Our Ref: SDNP/20/03305/ADJAUT
Contact Officer: Stella New
Tel. No.: [REDACTED]

Neighbouring Authority Consultation

Proposal: Adjacent Authority Consultation - A/109/20/RES - Approval of reserved matters following outline consent A/99/17/OUT for 175 No dwellings & associated infrastructure. This application may affect the setting of a listed building, may affect the character & appearance of the Angmering Conservation Area & falls within Strategic Site SD9, CIL Zone 1 (Zero Rated).

Address: Land South of Water Lane , Angmering

DRAWING 46353-STN-SBR-AB-DR-CB-0101

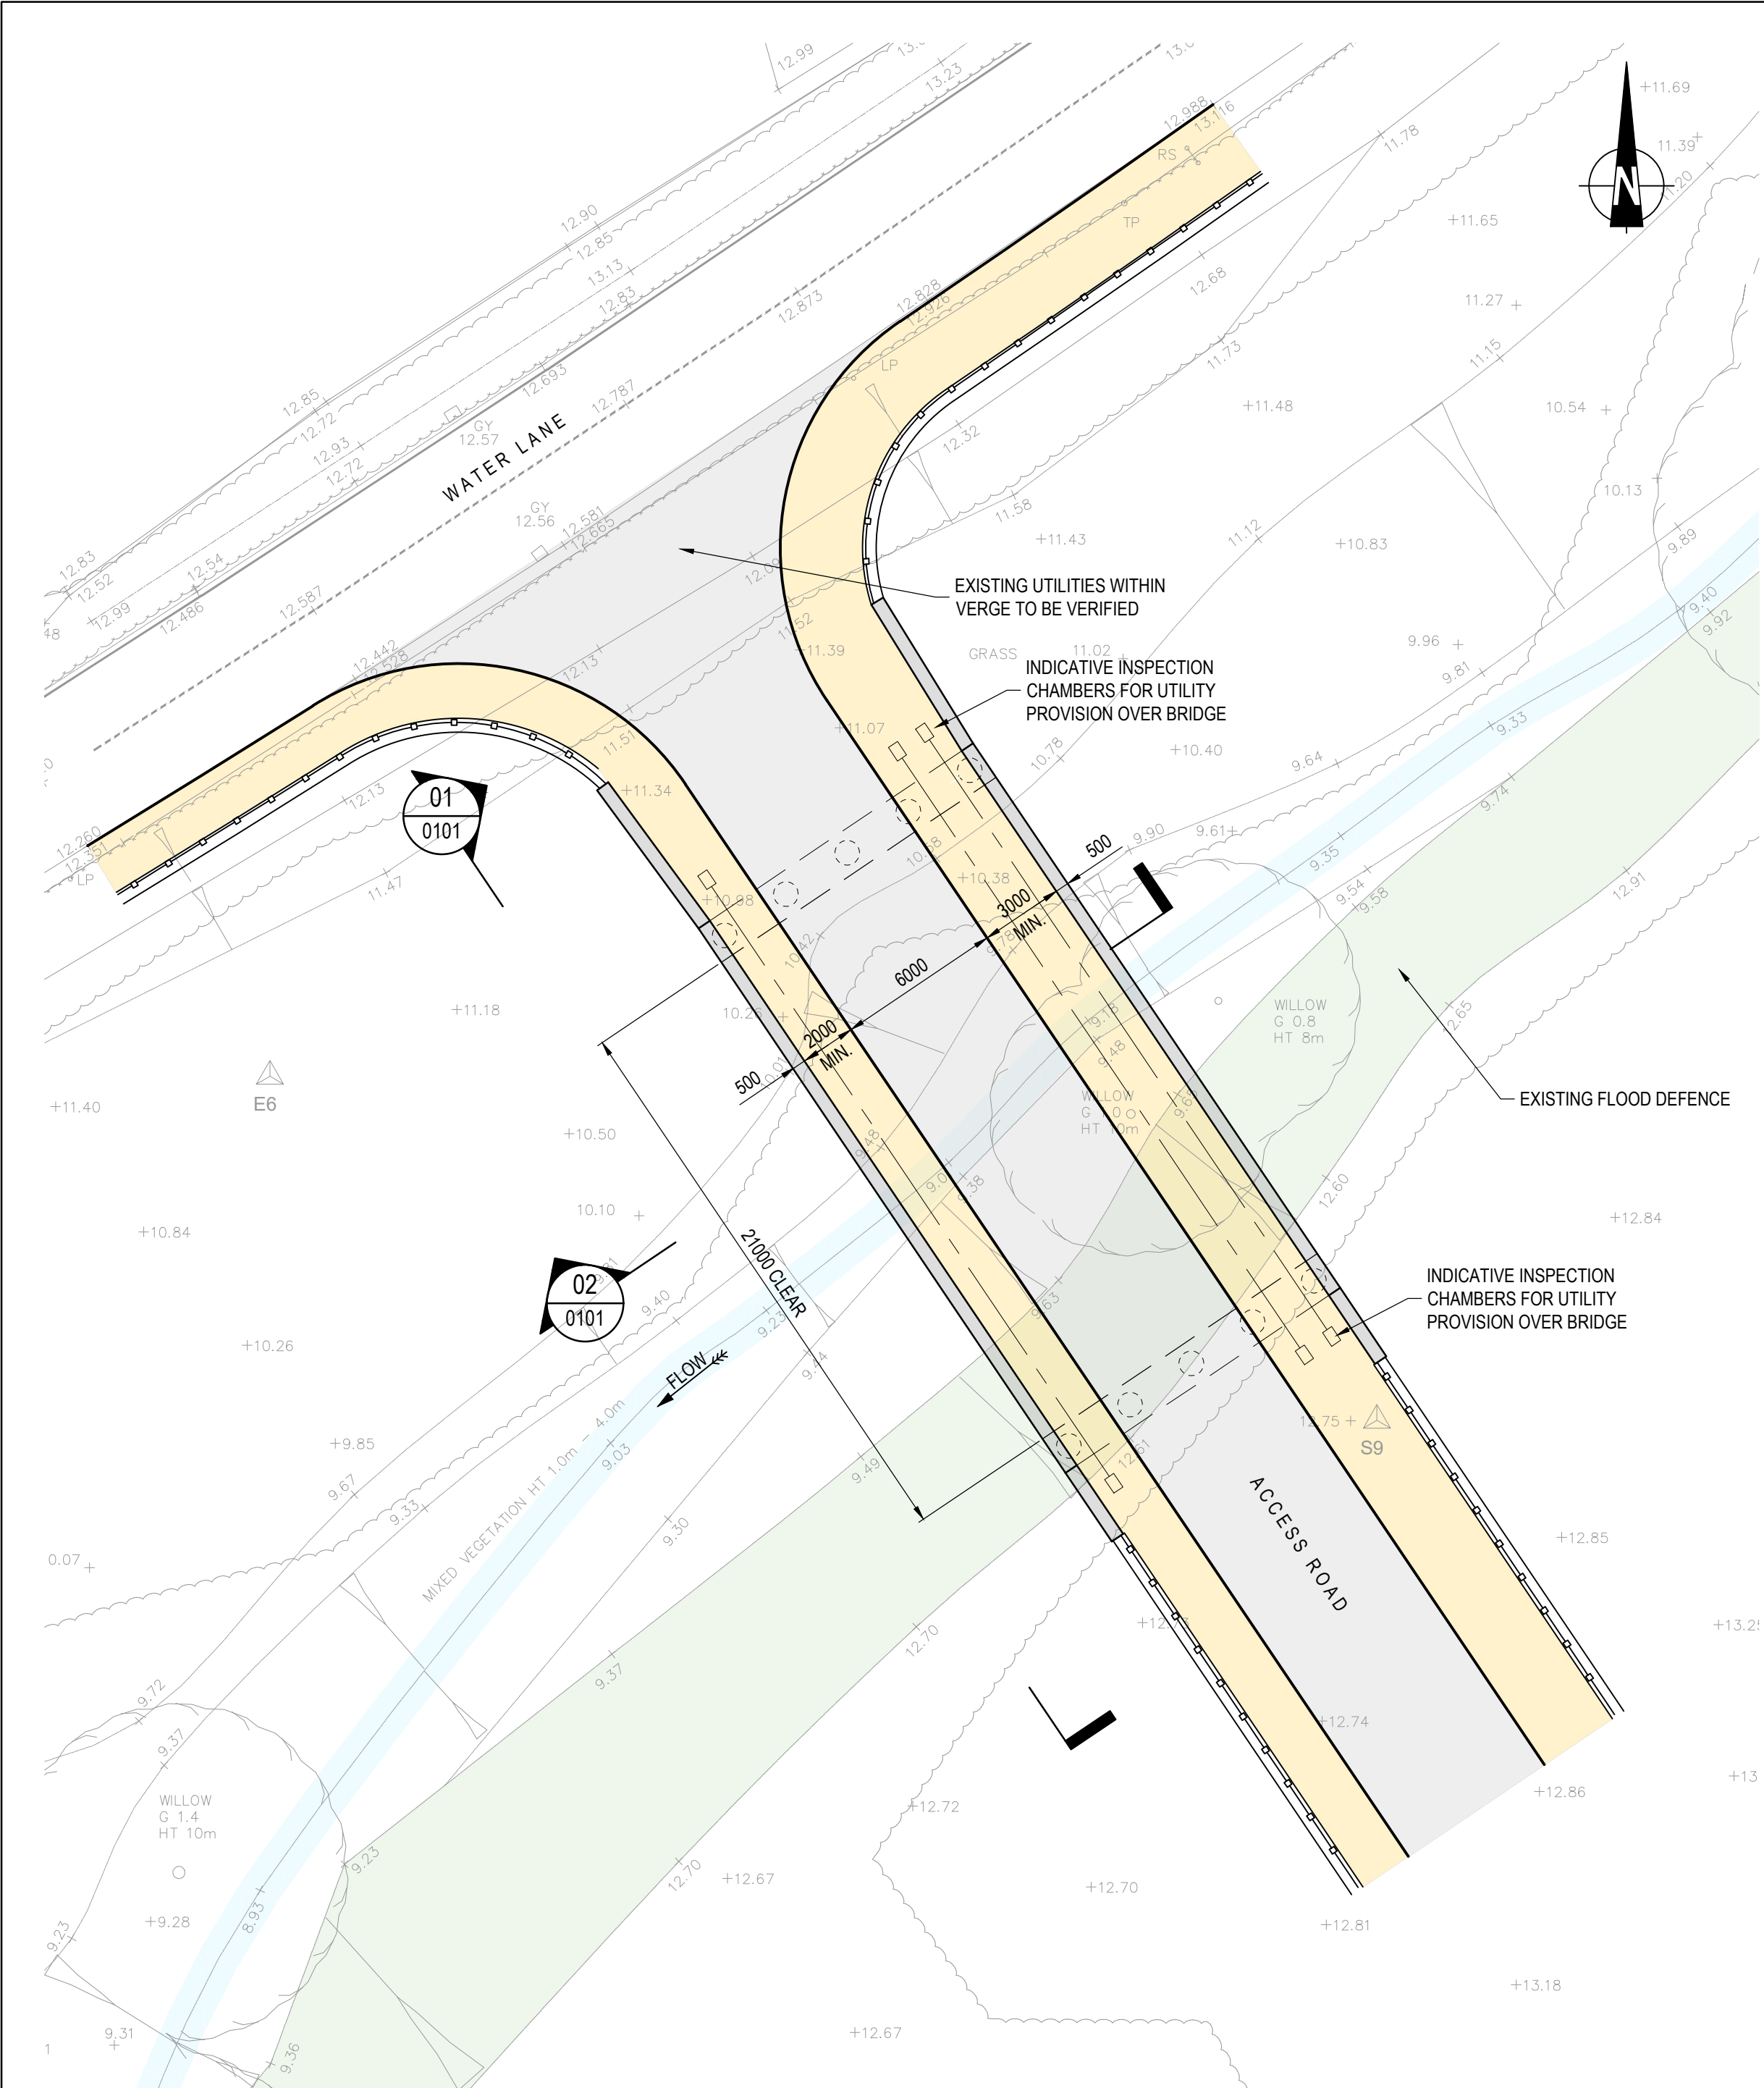
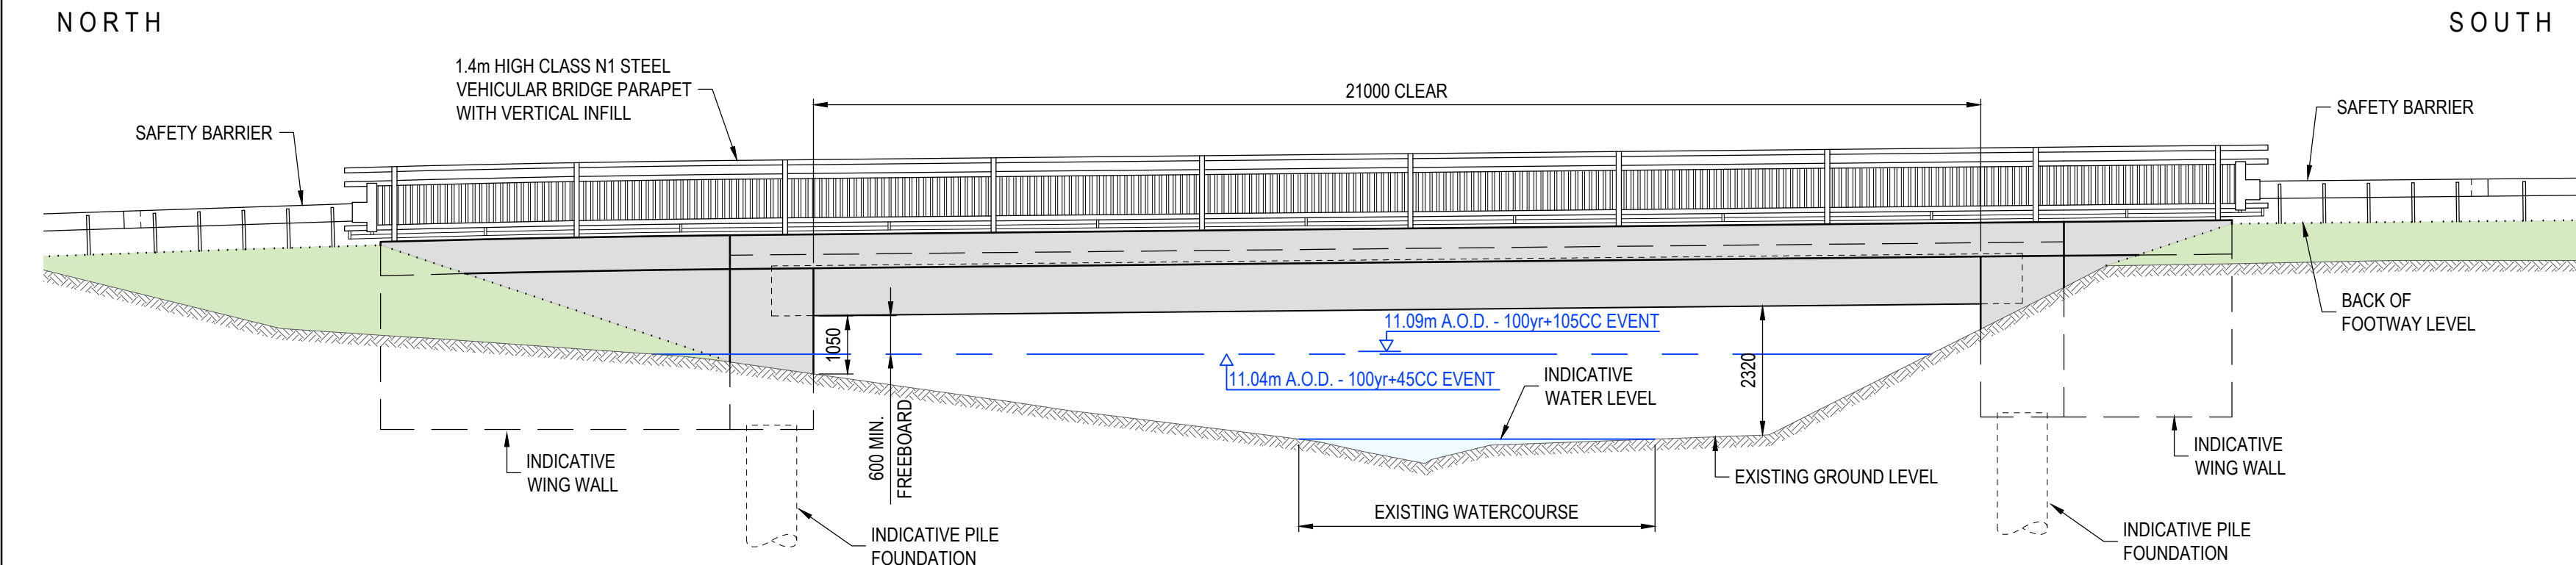
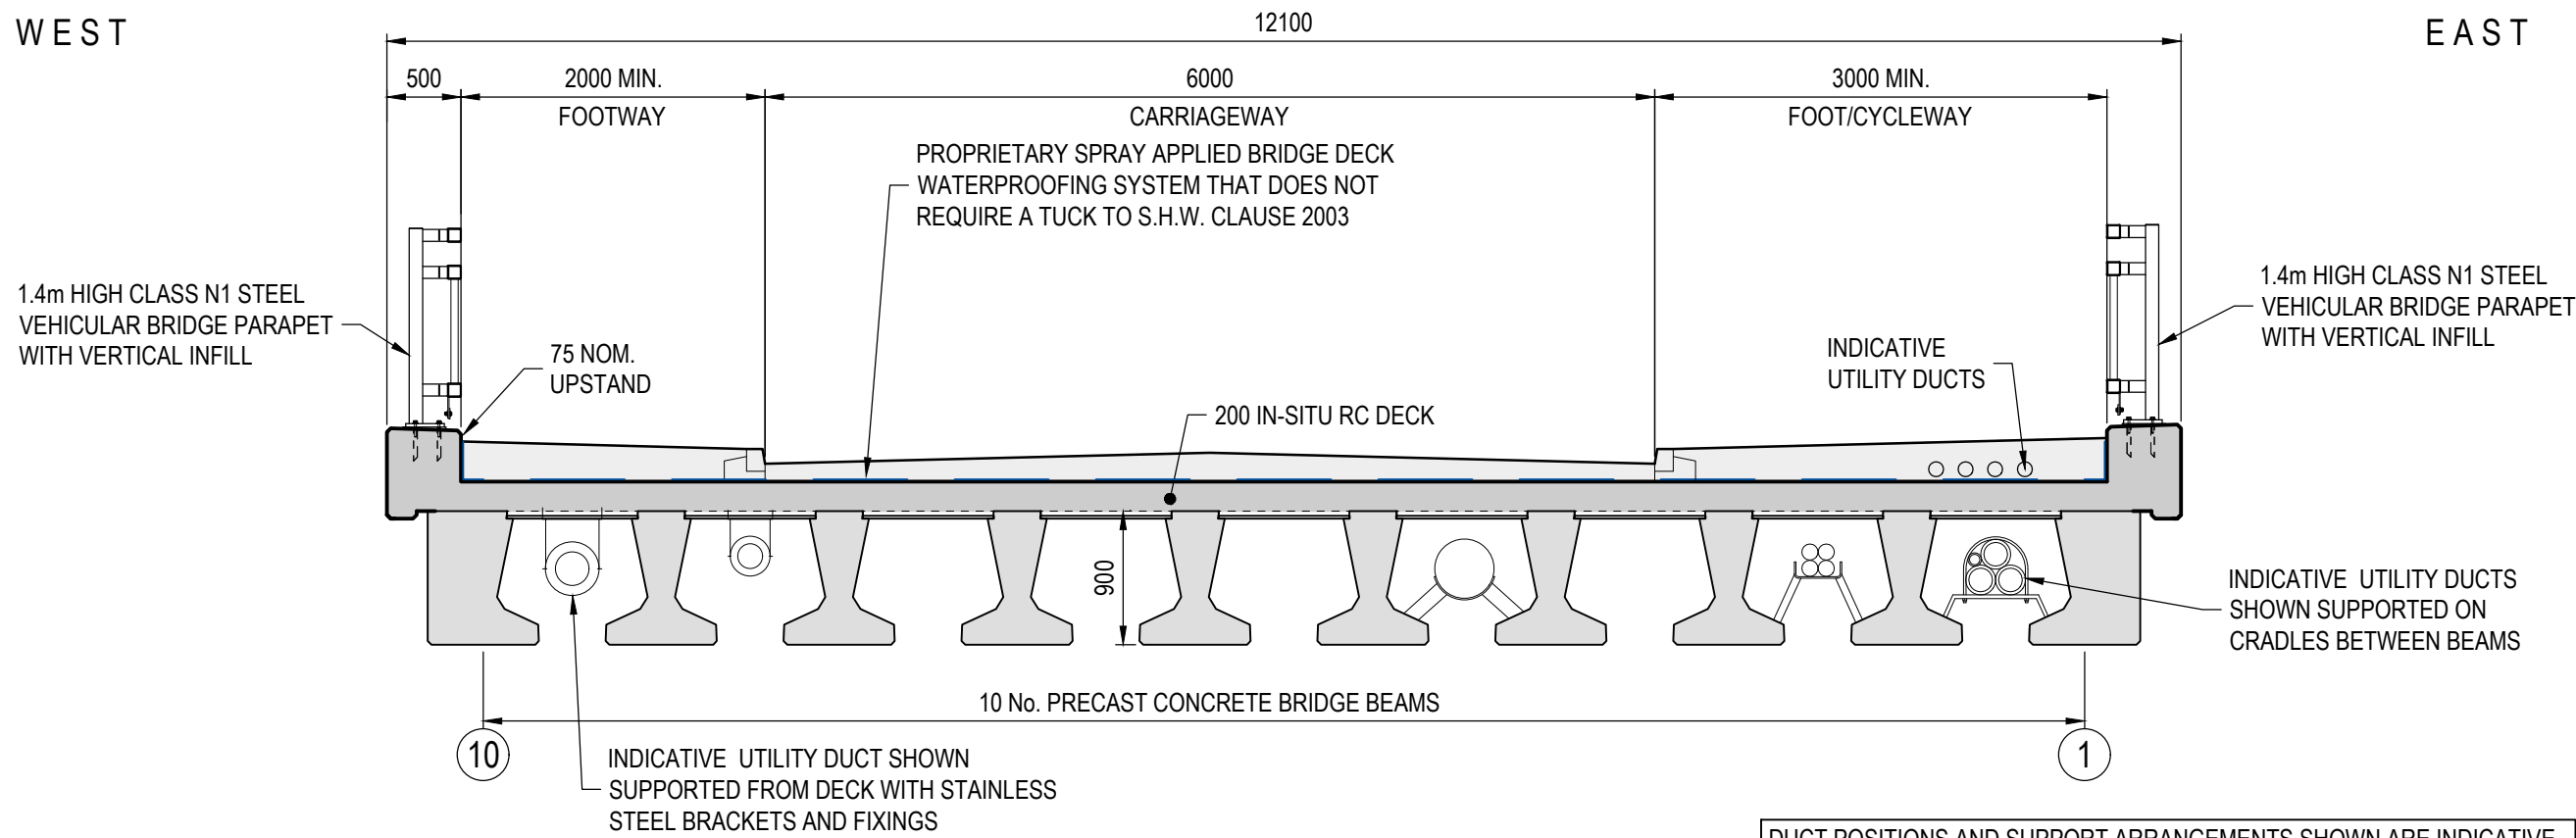
Thank you for consulting the SDNPA on this application for approval of reserved matters following outline consent A/99/17/OUT for a new Bridge over the Black Ditch providing access to the approved development.

In this instance, the bridge is necessary infrastructure for the delivery of the housing development. Any development within the setting of the National Park should positively contribute to ecosystem services and demonstrate environmental net gain and respect the setting of the National Park landscape. Opportunities to provide green infrastructure and additional habitat should be taken in order to conserve and where possible enhance the setting of the National Park. Details of native ruderal planting along the new verge and embankment profiles should be secured via condition to ensure these provide biodiversity net gain.

If minded to approve the application, the SDNPA recommend that full details of any street lighting along the bridge (both during and after the construction period) are secured by an appropriate planning condition with the intention of limiting light pollution and disturbance to wildlife.
